DRB CASE ACTION LOG - BLUE SHEET

Project# 1011013
16DRB-70346 MINOR - PRELIMINARY/
FINAL PLAT APPROVAL

TIERRA WEST LLC agent(s) for AOC NEW MEXICO, LLC request(s) the above action(s) for all or a portion of Tract(s) 2-B-1 AND 2-A, **NEW PORT INDUSTRIAL PARK WEST UNIT 1** zoned IP, located on RANDOLPH RD SE BETWEEN UNIVERSITY BLVD SE AND BUENA VISTA DR SE containing approximately 22.65 acre(s). (M-15)

**CITY OF ALBUQUERQUE
PLANNING DEPARTMENT
September 28, 2016
DRB Comments**

EXISTING
UTILITY PLAN

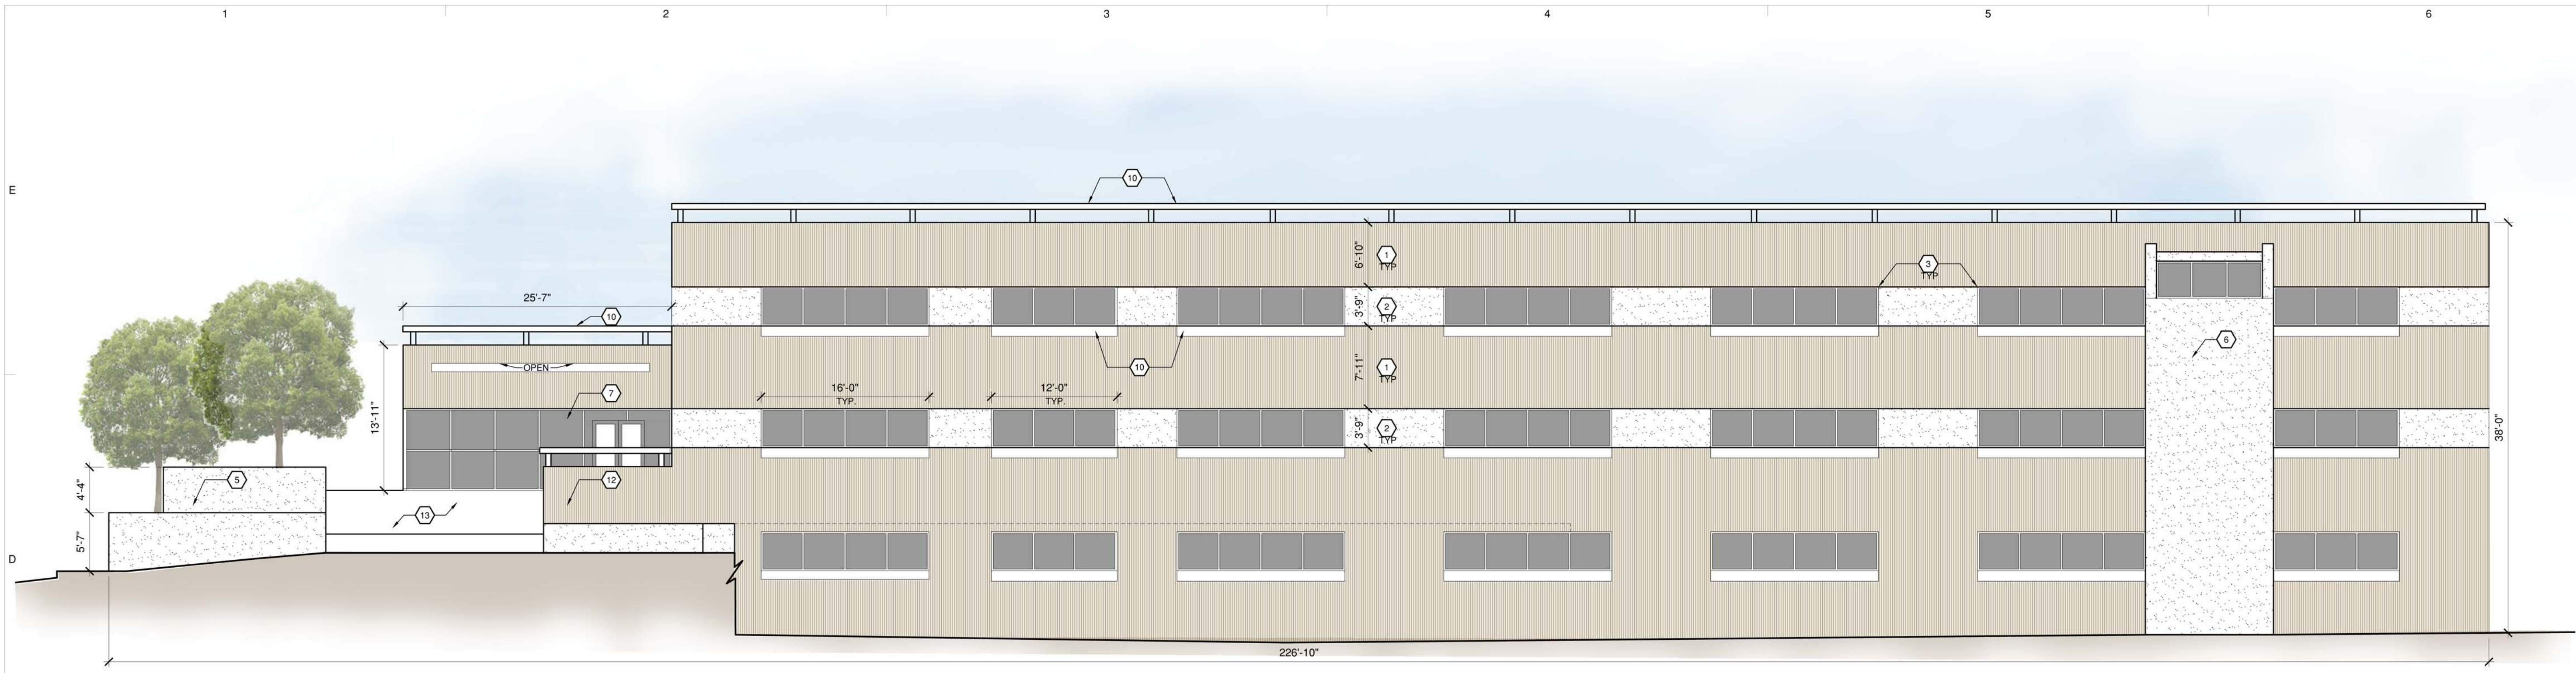
Planning: *amended site plan, utilities, det
revise "Public" to "PRIVATE" sheet*

INDEXING INFORMATION FOR COUNTY CLERK
 OWNER AOC NEW MEXICO LLC
 SECTION 33, TOWNSHIP 10 N., RANGE 03 E.
 UPC NO. 101-505-539-140-410-408 (TR. 2-B-1)
 UPC NO. 101-505-539-140-410-407 (TR. 2-A)
 SUBDIVISION NEWPORT INDUSTRIAL PARK-WEST UNIT 1

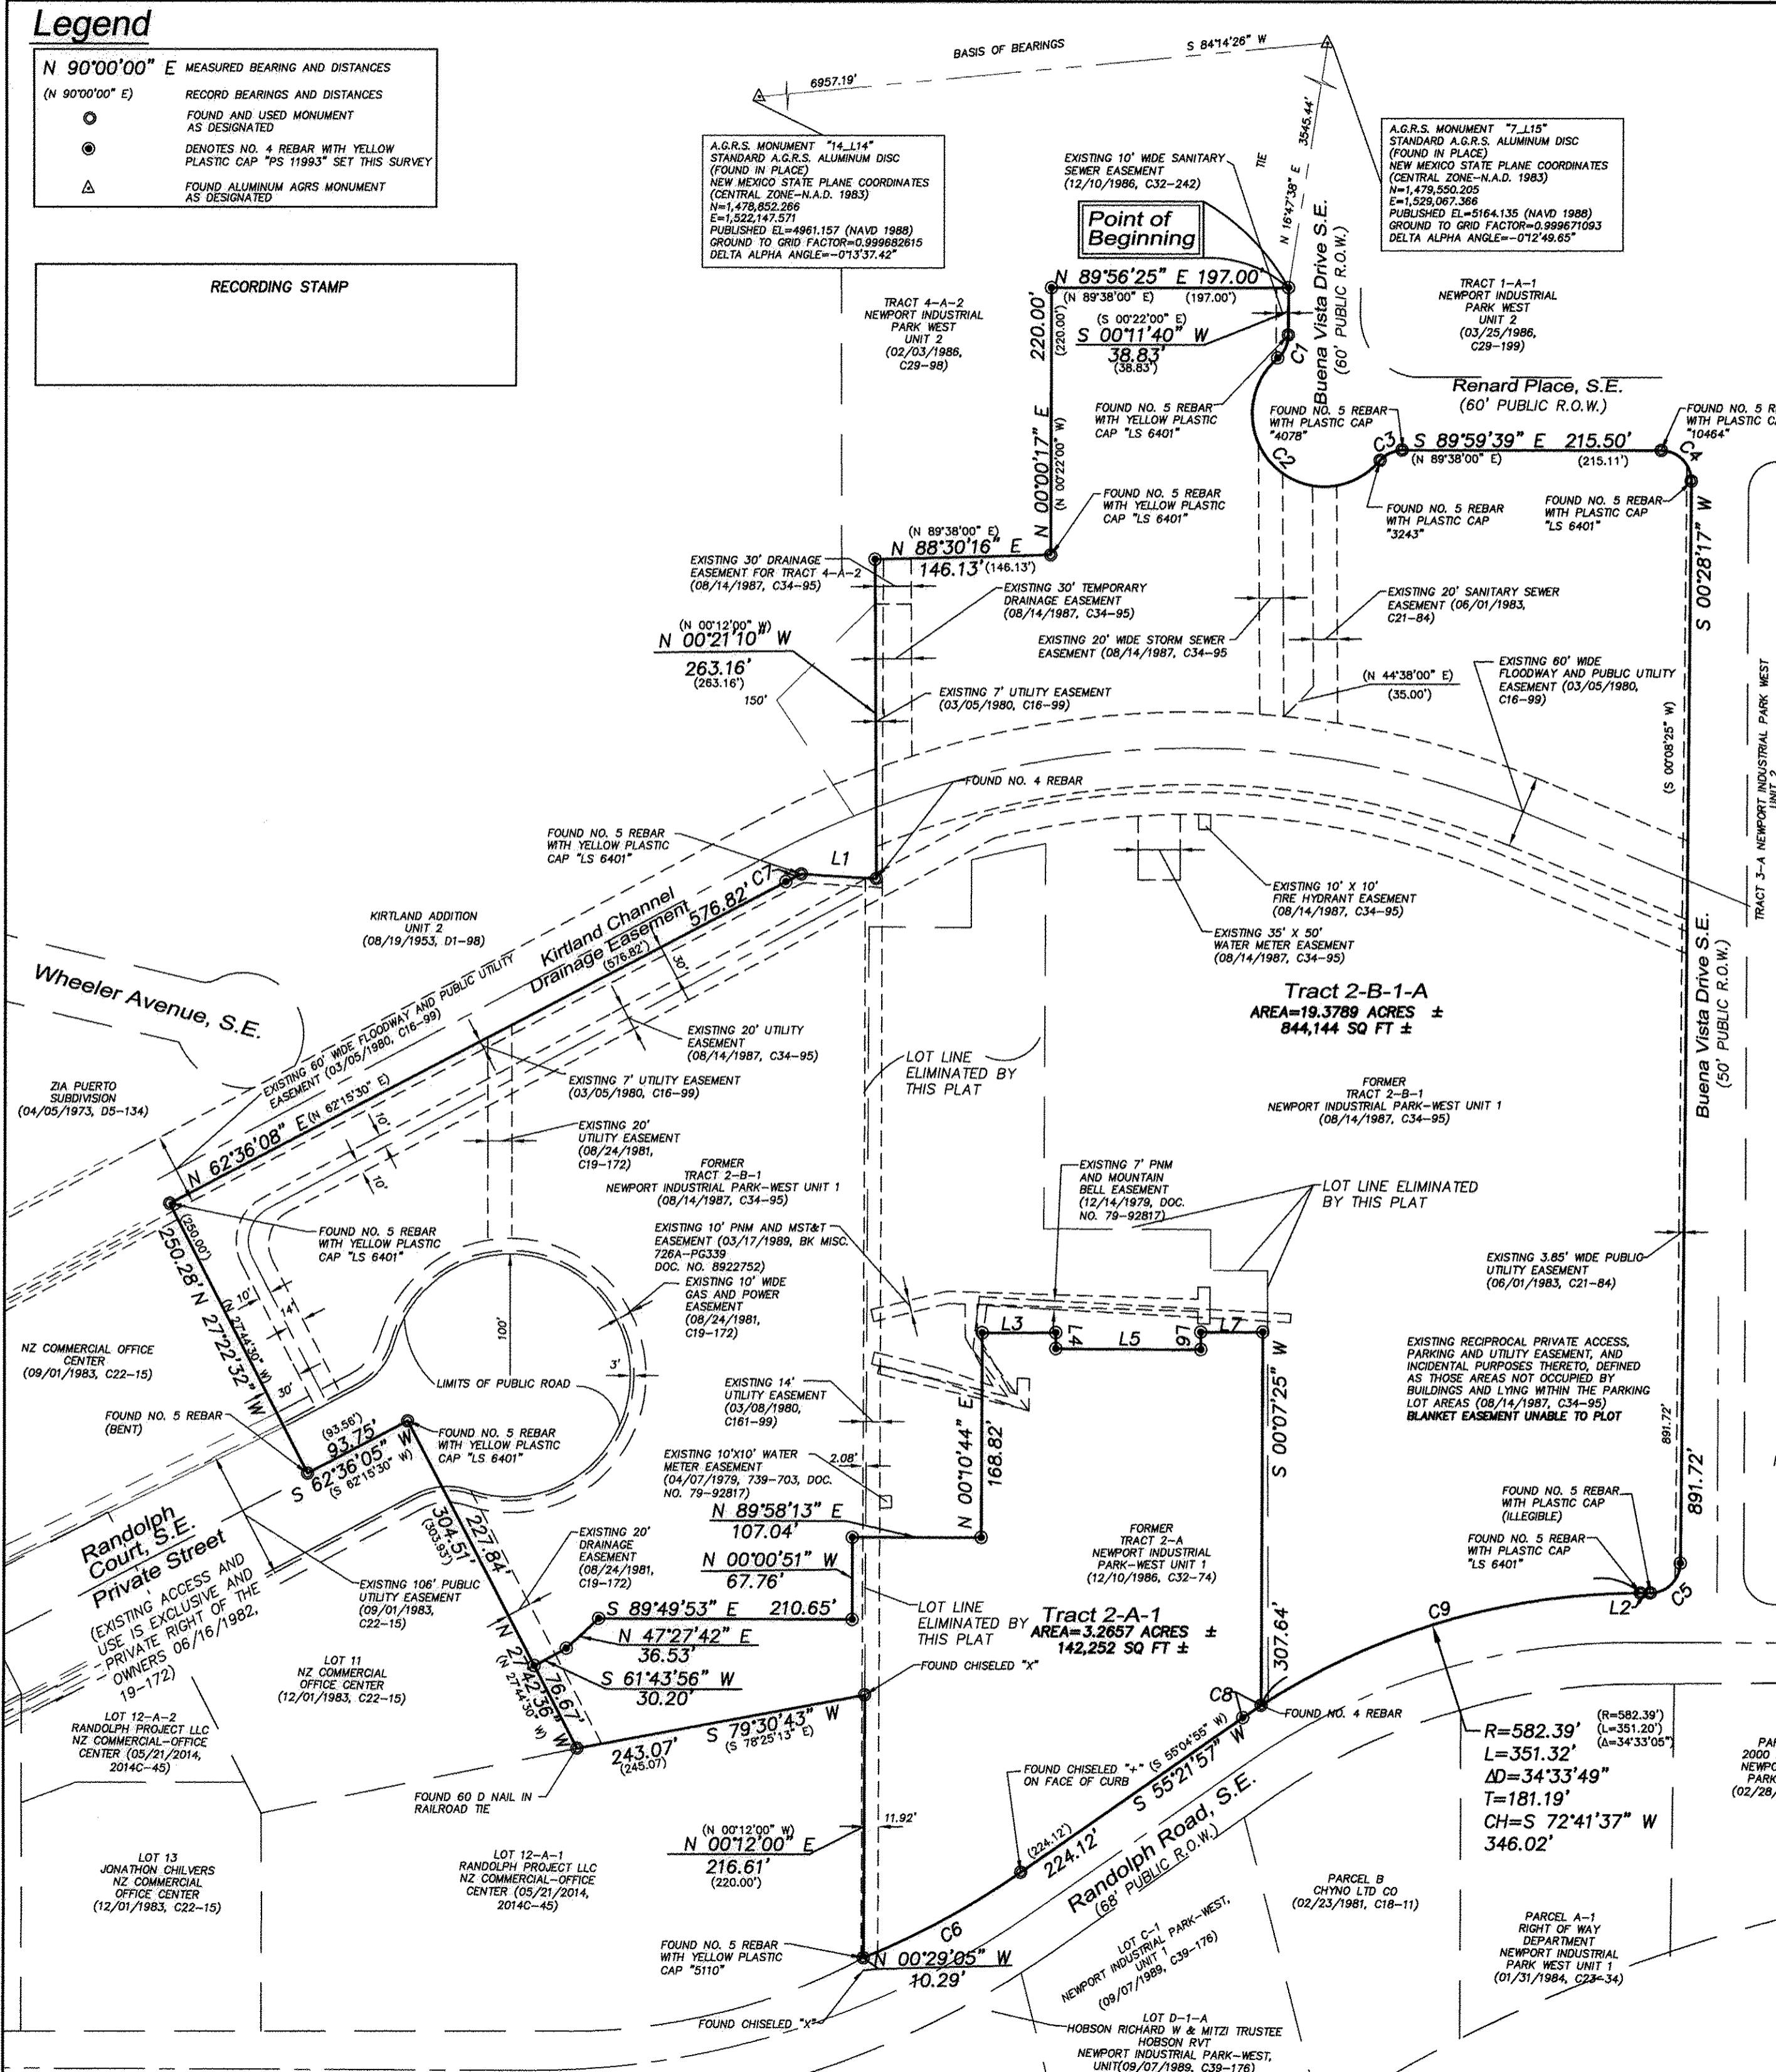
1. There are existing public waterline and public sanitary sewer lines along the channel. Have easements been confirmed for these facilities? Is it assumed that the 60' public utility easement is for the exiting Water Authority infrastructure?
2. Confirm easement for public waterline and public sanitary sewer along Randolph Court (private street). Plat indicates "limits of public road" yet it's within the private property.
3. Consultant states that each property will still maintain individual water services and sanitary sewer services without the need for private easements.

- Crosslot Drainage easement needed between the new tracts.
